KITTITAS COUNTY

DEPARTMENT OF PUBLIC WORKS

MEMORANDUM

TO: Jeff Watson, CDS
FROM: Christina Wollman, Planner II *CW*
DATE: January 15, 2014
SUBJECT: Wenger Short Plat SP-07-07

KITTITAS COUNTY SHORT PLAT NO. 07-07
PORTION OF THE NE 1/4, SEC.29 T.20N., R.14E., W.M.
KITTITAS COUNTY, WASHINGTON

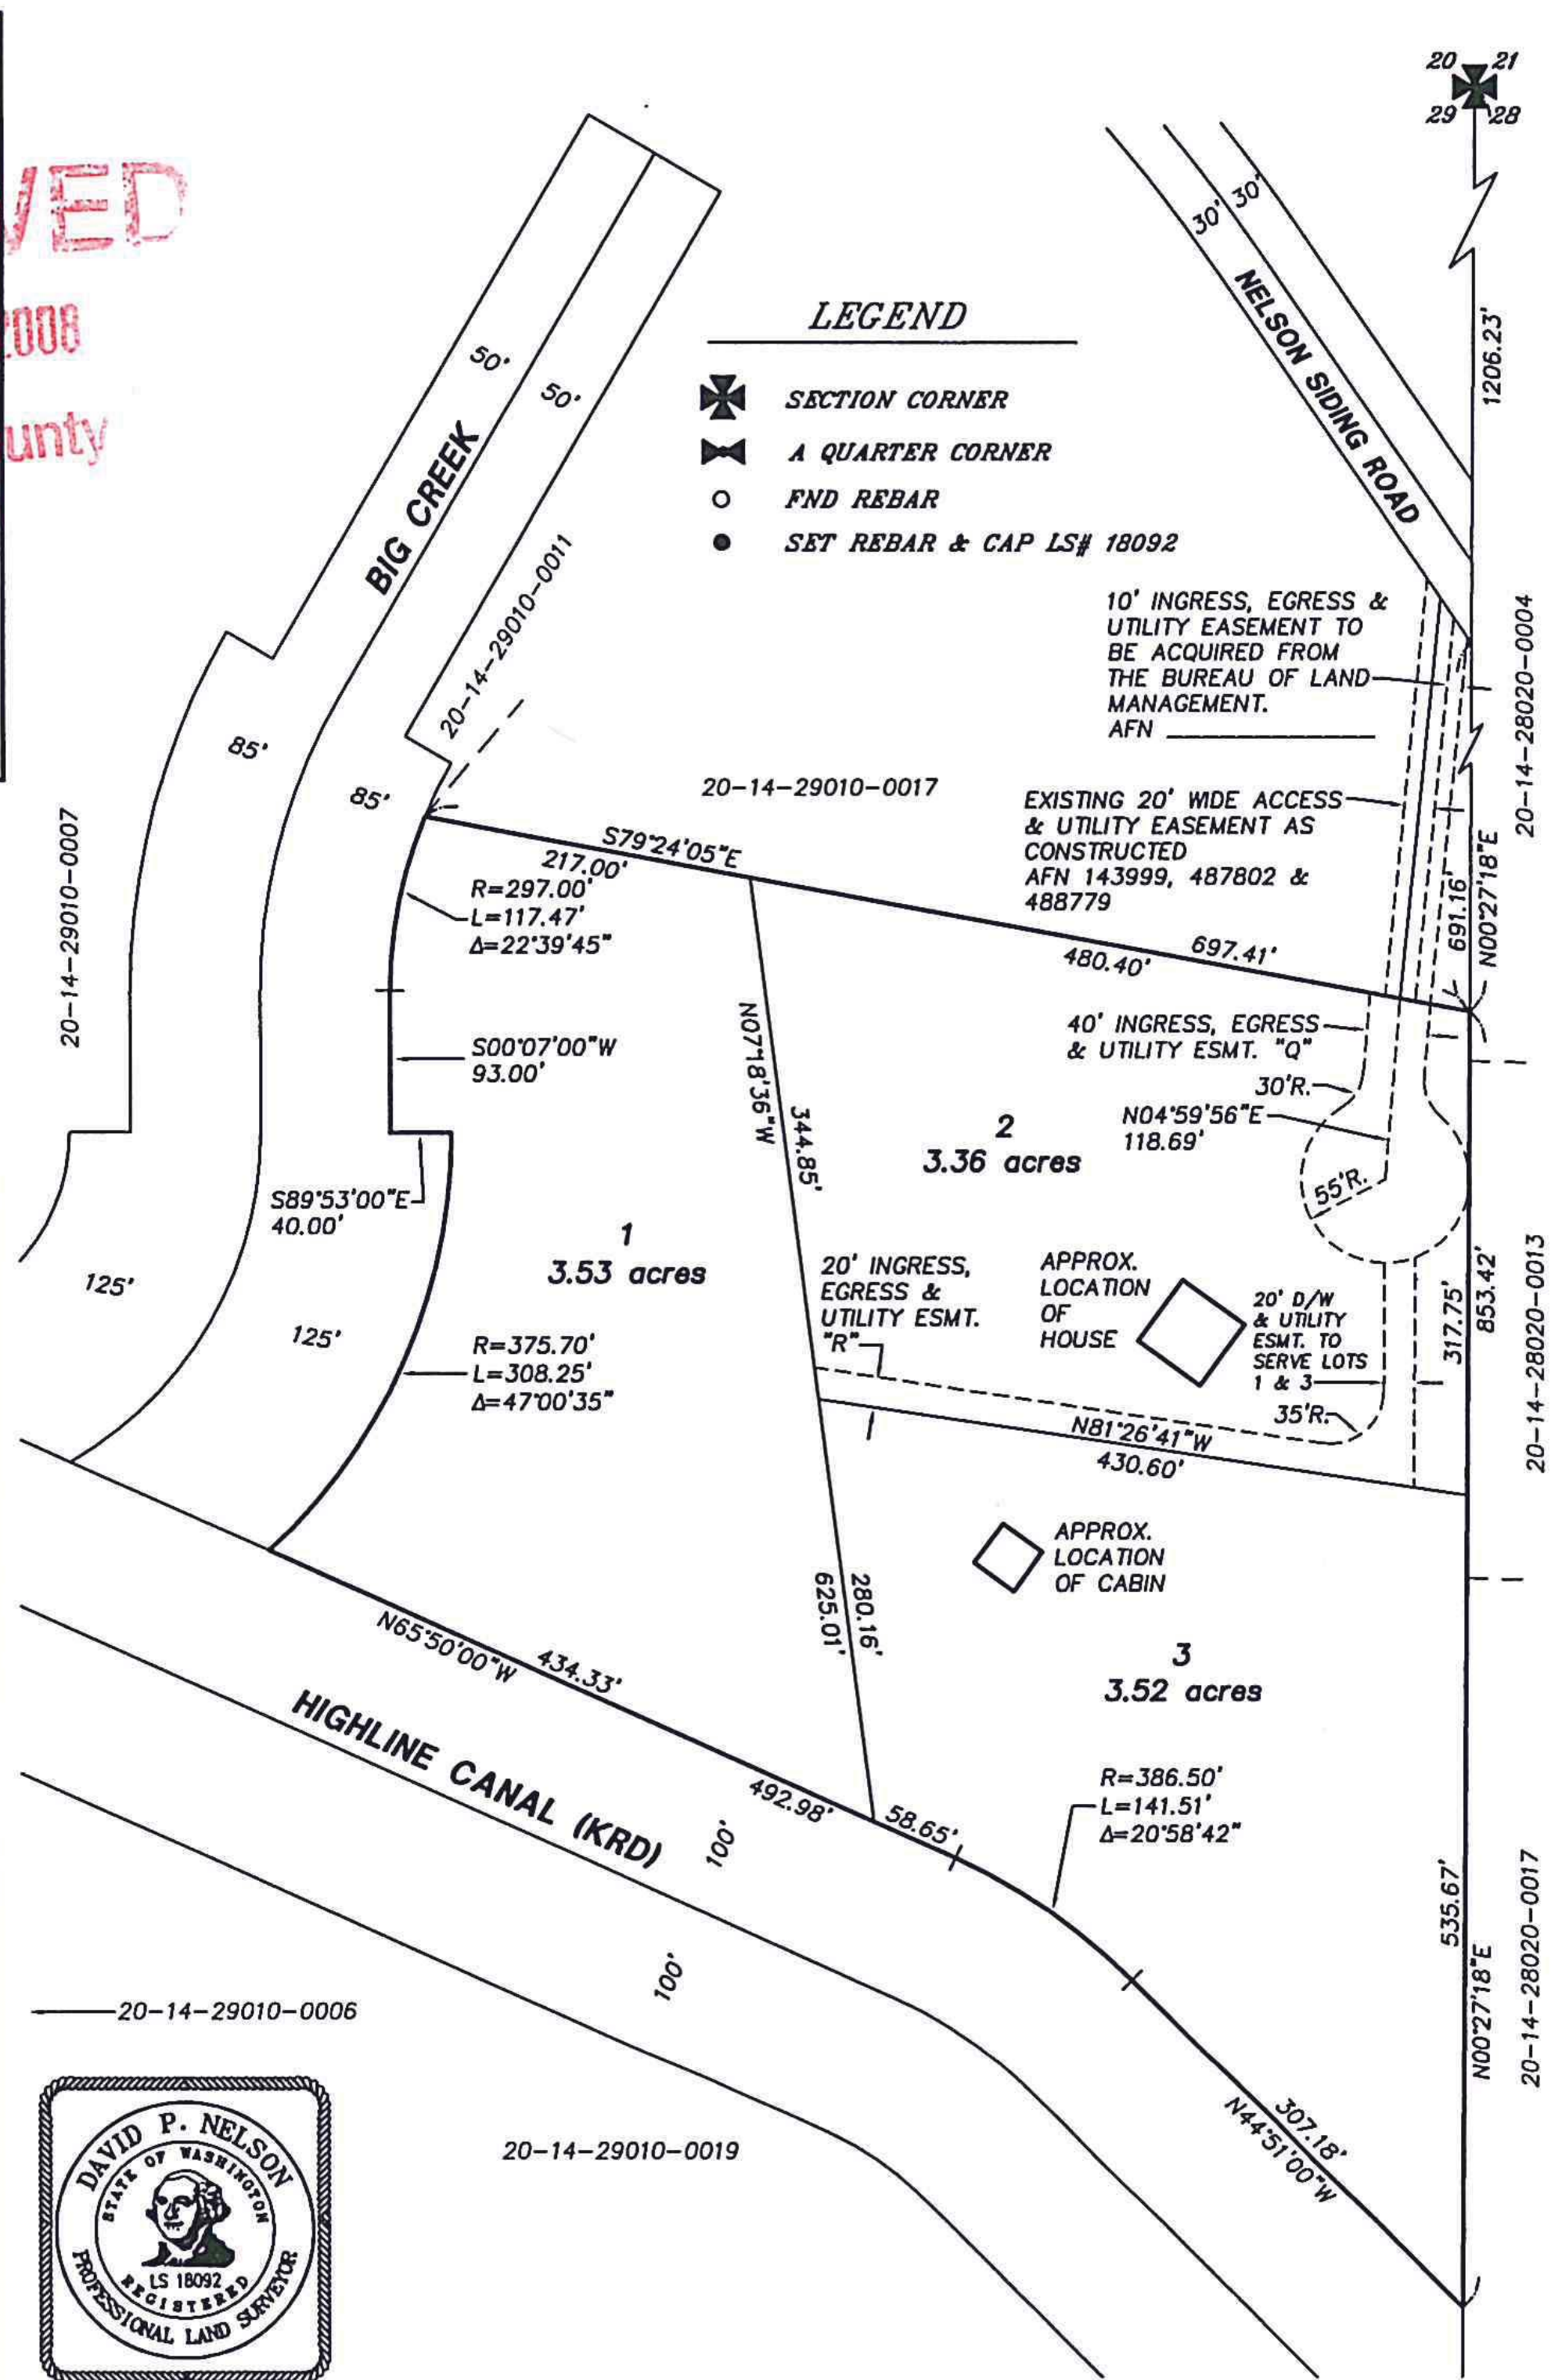
1. The 100-year floodplain must be shown on the preliminary short plat to ensure there is a buildable area outside of the 100-year floodplain on all parcels. This will prevent the landowner from needing to hire a hydraulic engineer to do a study. Unfortunately the parcel lines and floodplain boundaries on our maps are not accurate enough to make a visual determination.

2. For review purposes, the 200' shoreline jurisdiction must be shown on the preliminary short plat.
3. The location of Big Creek must be shown on the preliminary plat for reference.

4. The location of the KRD Lateral boundaries must be shown on the plat for review purposes and to ensure there is no encroachment.
5. Easement and actual driveway location for the road serving parcel 616536.

6. Revised road plans within the subject property, to show the relocated cul-de-sac and driveway. The easement within the subject property must be 60' wide and there cannot be more than two lots served off the end of the cul-de-sac.
